**THE RESERVE AT CORRAL BLUFFS FILING NO. 3**  
 A PORTION OF THE EAST HALF OF SECTION 31 AND WEST HALF OF SECTION 32  
 TOWNSHIP 13 SOUTH, RANGE 64 WEST OF THE 6TH P.M.  
 EL PASO COUNTY, COLORADO

# Final Plat\_V1.pdf Markup Summary

THE RESERVE AT CORRAL BLUFFS FILING NO. 3

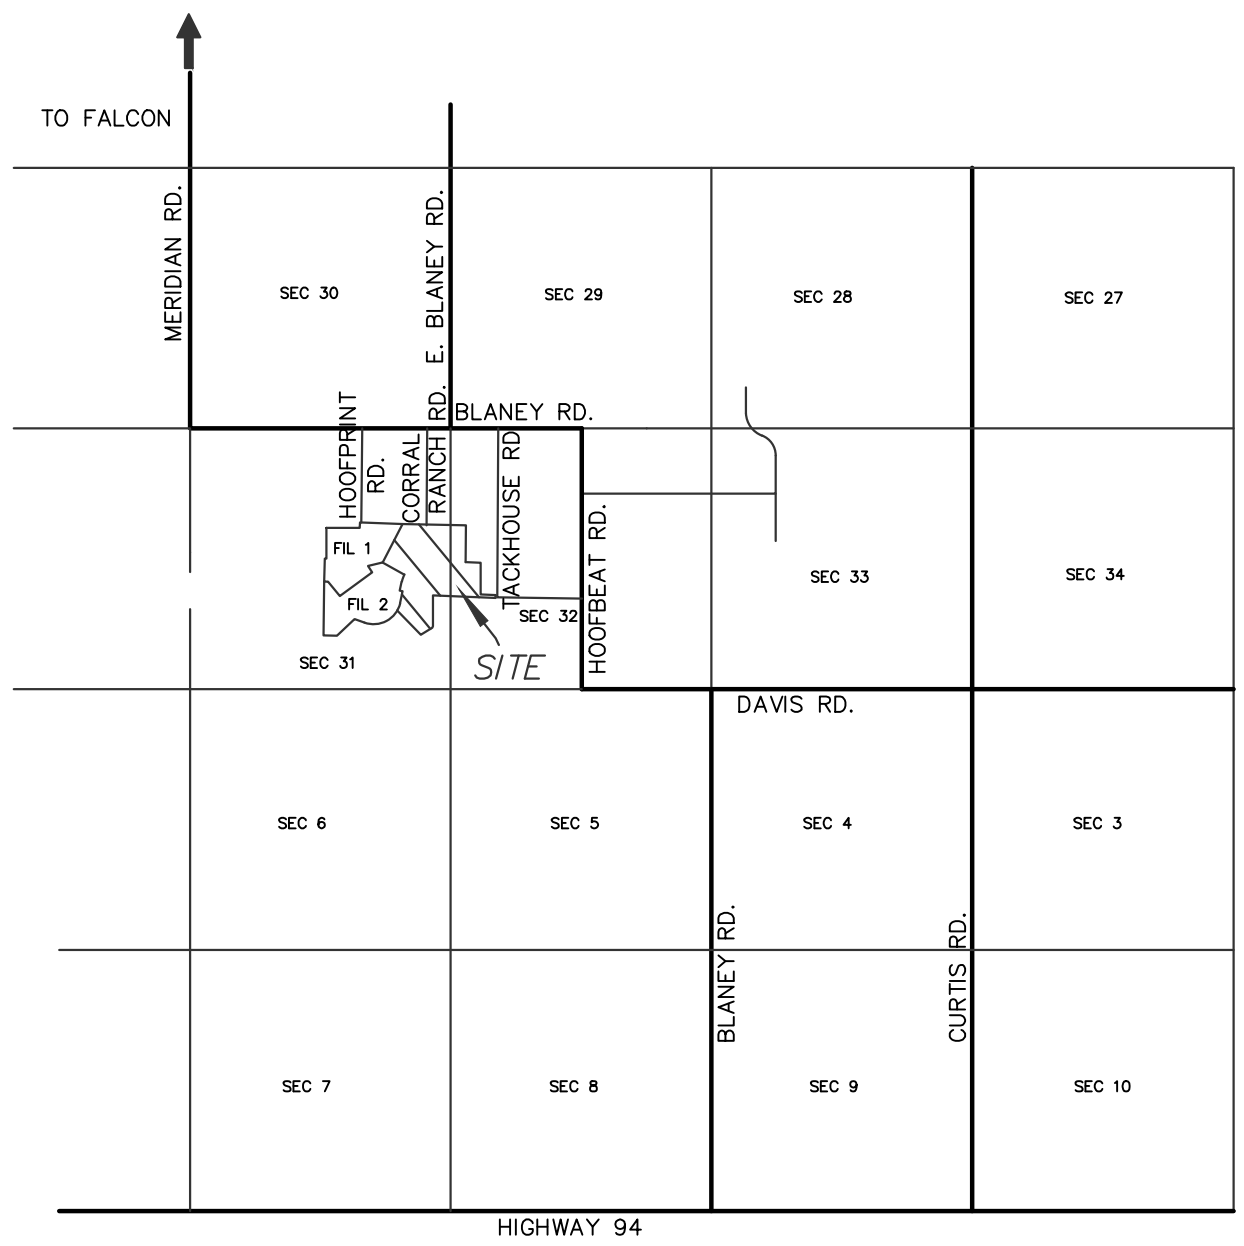
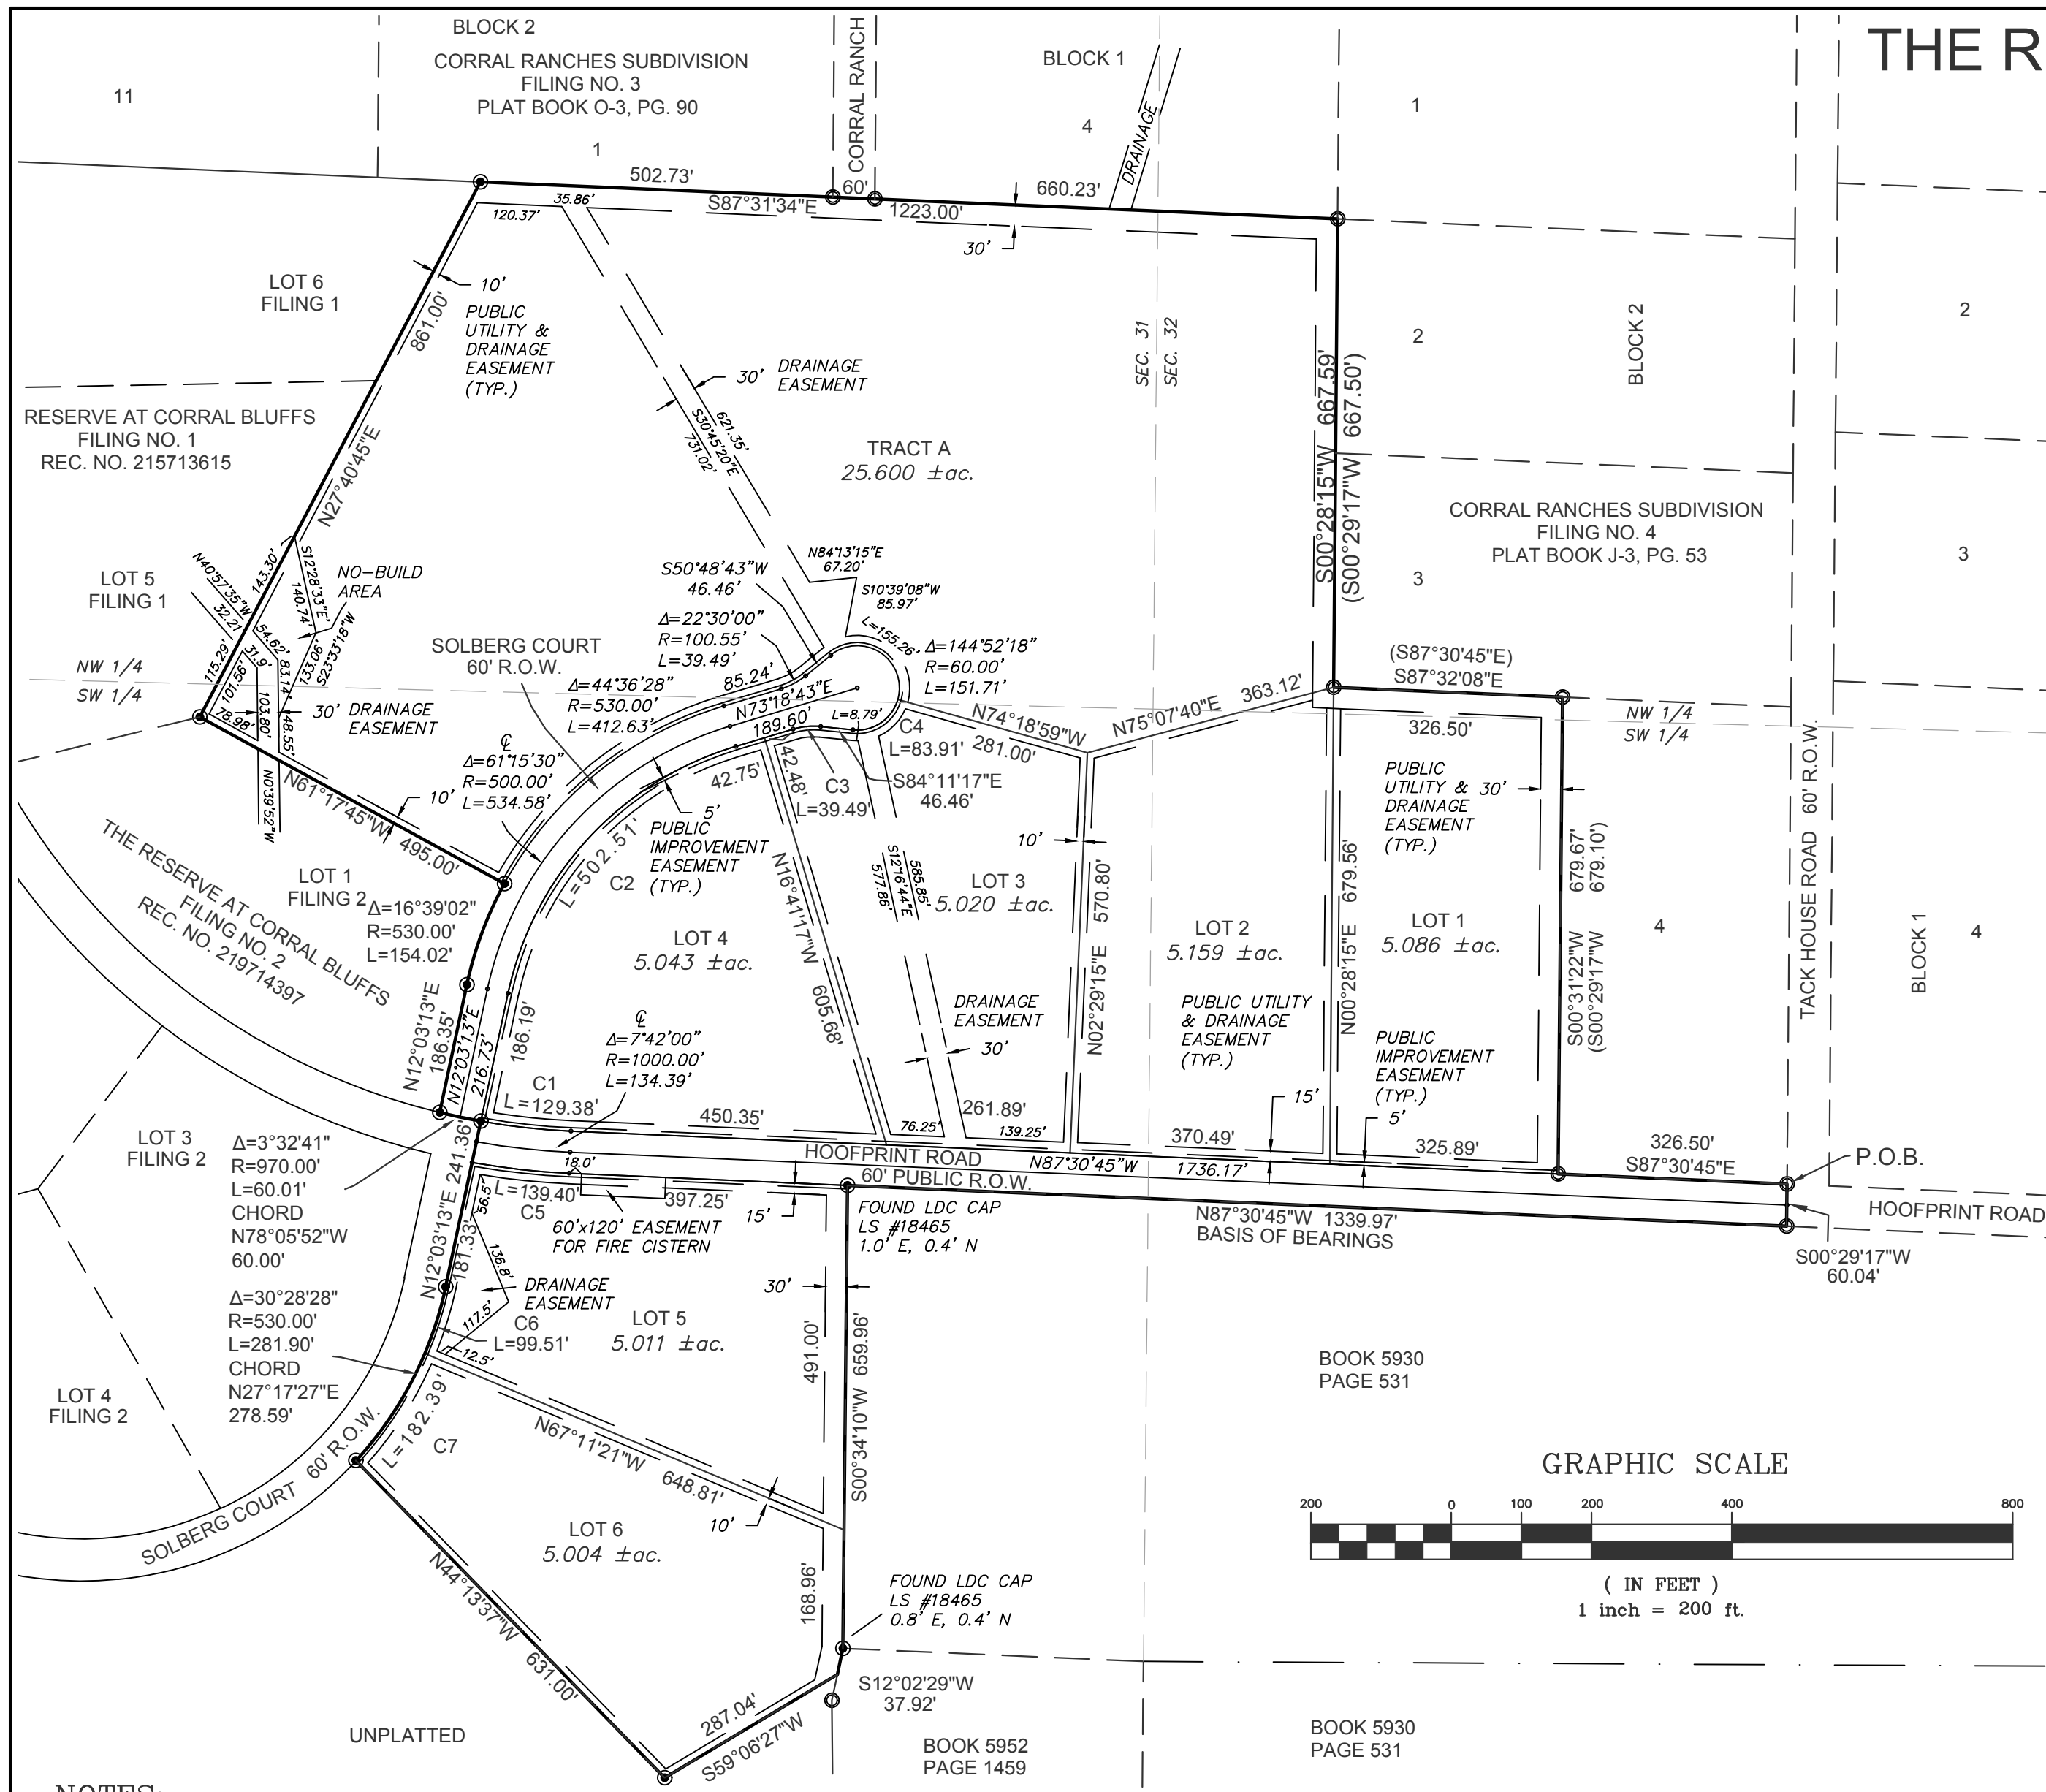
Indicate the ROW for Hoofprint Road

Please revise to include public improvements as shown on the road cross-section in the construction documents.

If these are Type 3 cluster boxes, update plans and plat to meet ECM Chapter 4 Section 4.4.5.E for mailbox placement.  
 "Type 3 mailbox and the pullout for the mailbox shall be located within the ROW but outside the roadway clearzone.

verify correct recording for covenants, should have been reviewed by County Attorney prior to recordation

verify information, soils and geology report indicate impacts to Lots 1, 2, 3, 4, 6, and tract A, and areas of ponding water should be no-build areas
